**From:** Esther Frizell-Armitage  
**Sent:** 7 Apr 2021 14:10:04 +0100  
**To:** Joan Desmond  
**Cc:** Planning (WODC)  
**Subject:** 21/00592/FUL, Rynehill Farm, Assistant Biodiversity Officer response

Thank you for consulting me on the above planning application (application no. 21/00592/FUL). I have reviewed the Preliminary Bat Survey, prepared by 4 Acre Ecology and dated 15<sup>th</sup> February 2021. I have the following comments where further information is required before a positive determination the application.

Proposed Layout & Elevations

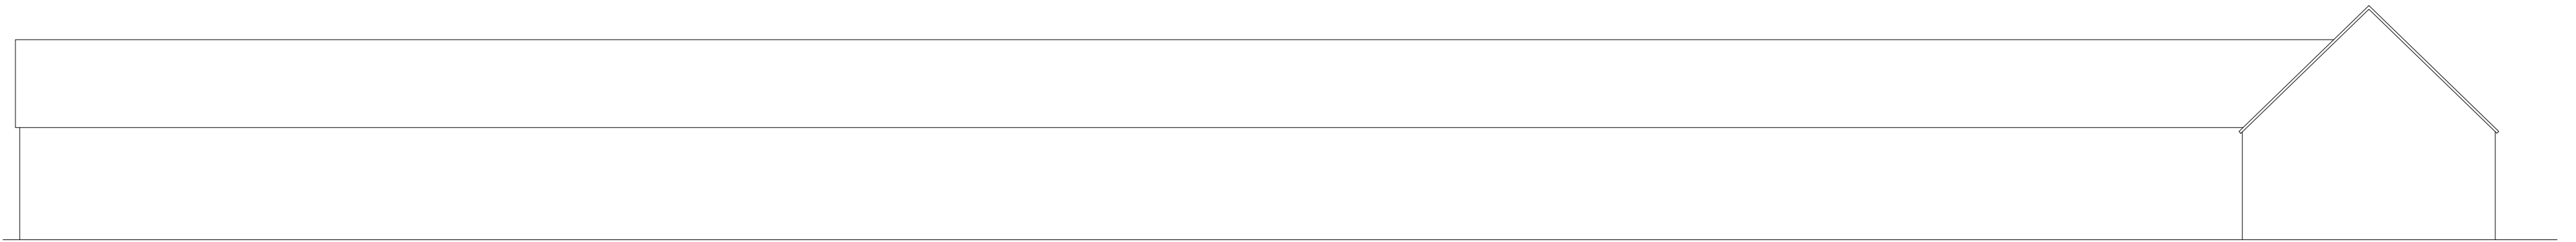
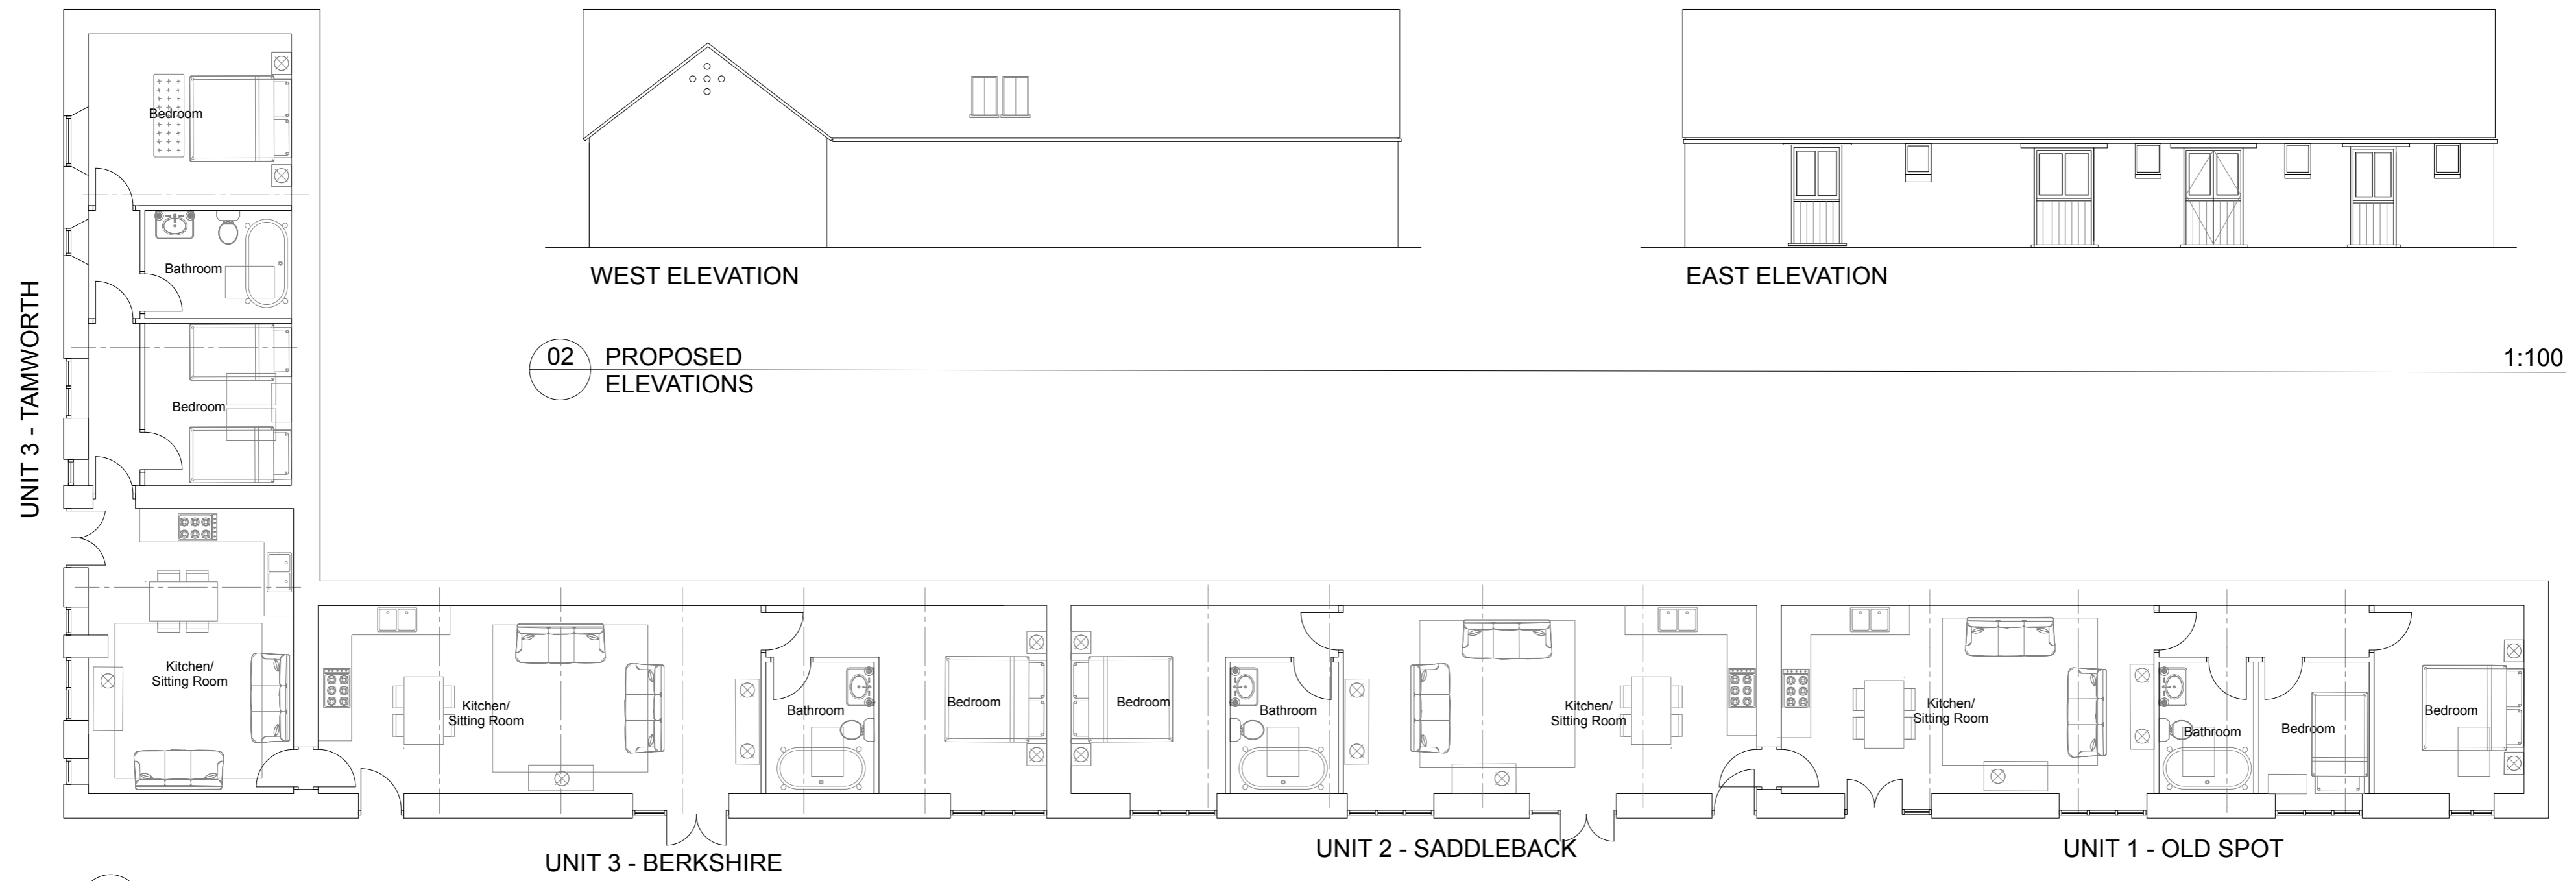
The architectural plans will need to show nesting features to compensate for the loss of those on site. For example, I recommend that at least 4 no. swallow nest cups are provided as well as a house sparrow terrace (a design with 3 no. holes). The designs of the new features should be provided along with the positions on the elevations of the building. These details will need to be submitted before a positive determination of the application to ensure that sufficient compensation for nesting birds is incorporated into the scheme. The nesting features should be located along the northern or eastern elevations of the building, and not directly above any doors or windows.
